Application for Removal or Variation of a Condition following Grant of Planning Permission or Listed Building Consent

Number	<input type="text" value="17"/>
Suffix	<input type="text"/>
Property Name	<input type="text"/>
Address Line 1	<input type="text" value="Avon Way"/>
Address Line 2	<input type="text"/>
Address Line 3	<input type="text" value="South Gloucestershire"/>
Town/city	<input type="text" value="Thornbury"/>
Postcode	<input type="text" value="BS35 2DG"/>

Erection of 1 no. ancillary annexe.

P23/01466/F

Section AA

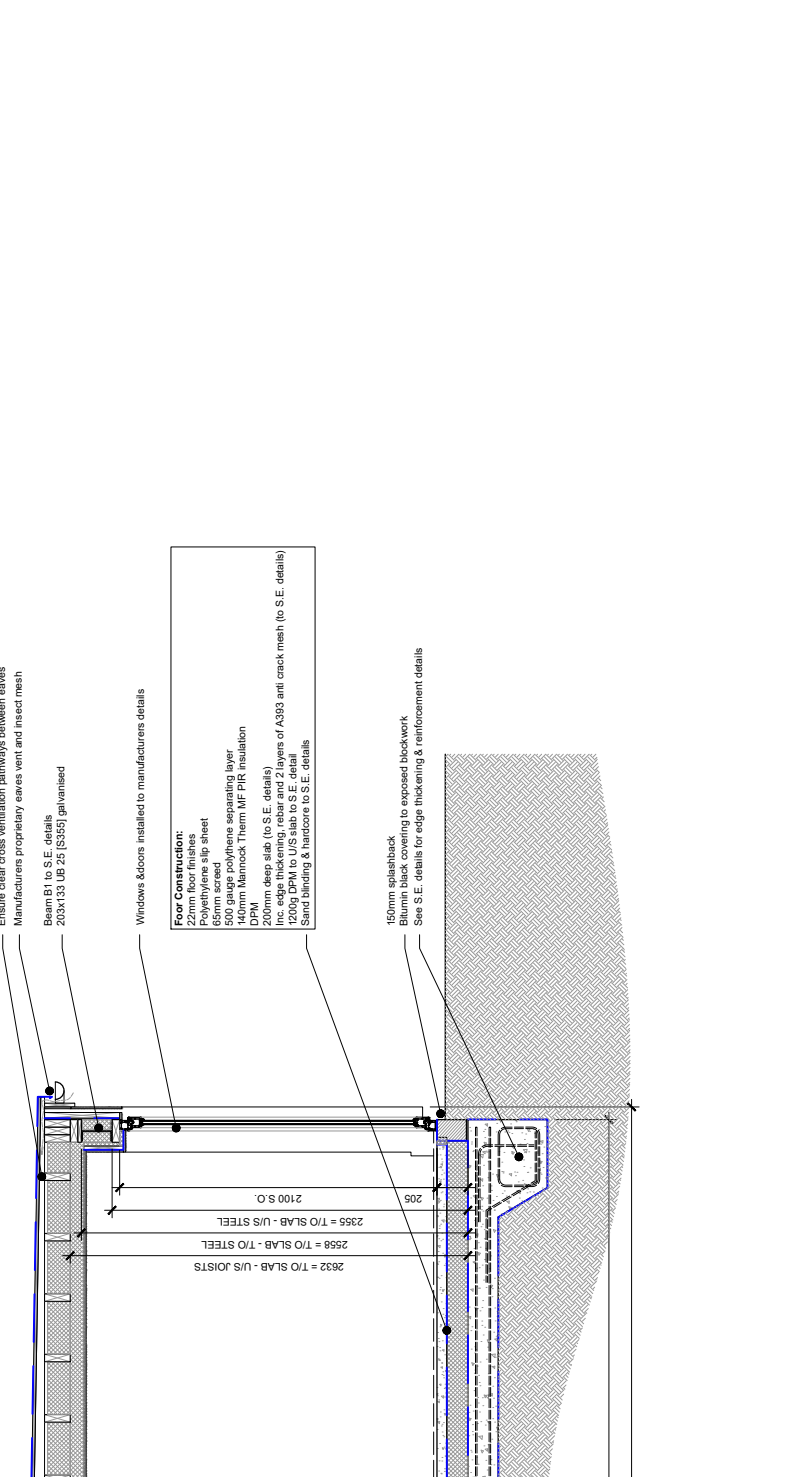
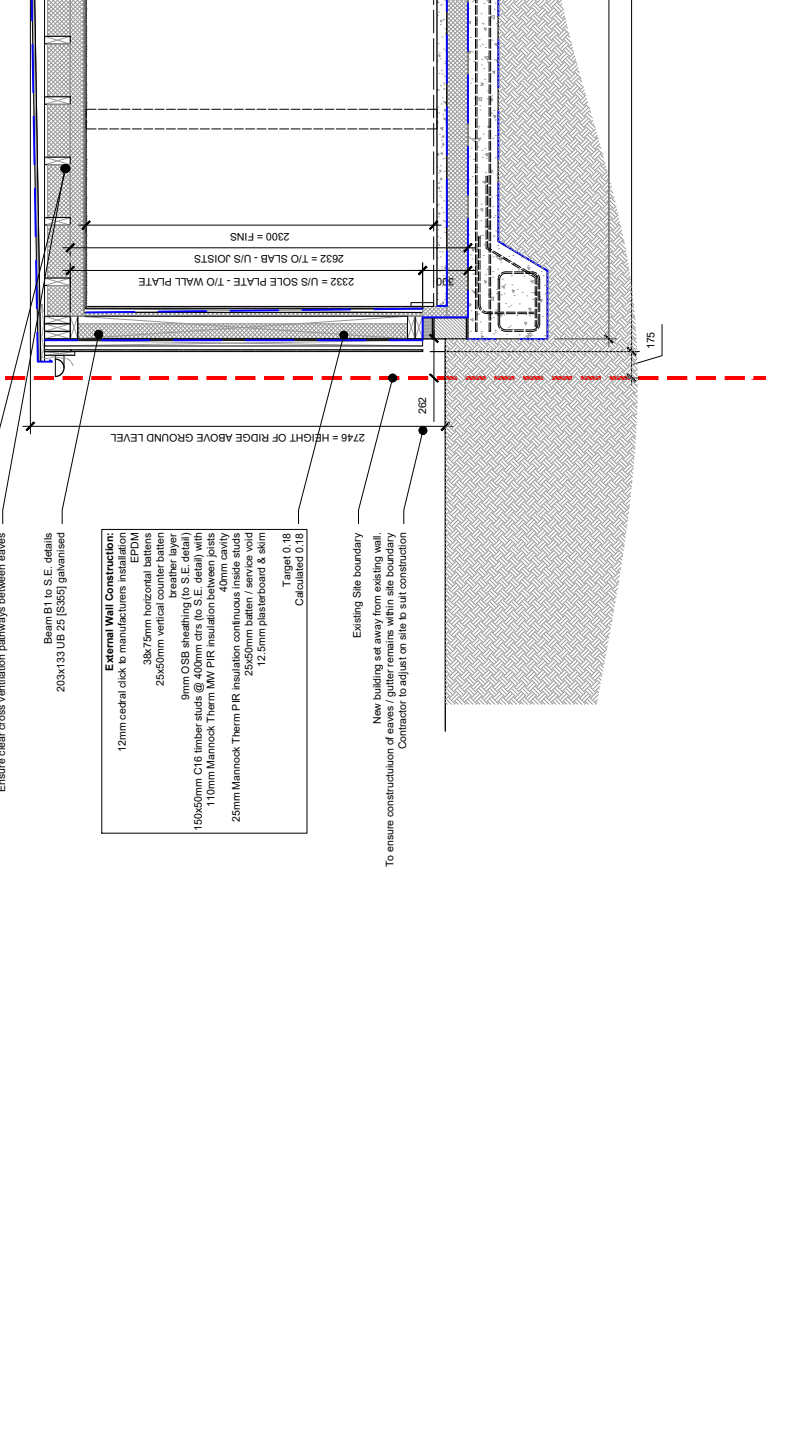
There are two changes:

1. The height of the annexe has increased from 2.5 metres to 2.75 metres to ensure enough available head room and to ensure that the required thickness of thermal insulation can be incorporated into the roof to achieve Building Regulation compliance.
2. The parapets shown on the planning drawing have been omitted as a means to ensure adequate headroom and thermal insulation thicknesses as noted above. The standard external gutter solution shown on our attached drawings is also easier to construct (and therefore cheaper to build) than the parapet originally proposed would have been.
3. The building has moved away from the boundary to ensure all construction occurs within the bounds of 17 Avon Way and allow for the adequate construction of foundations.
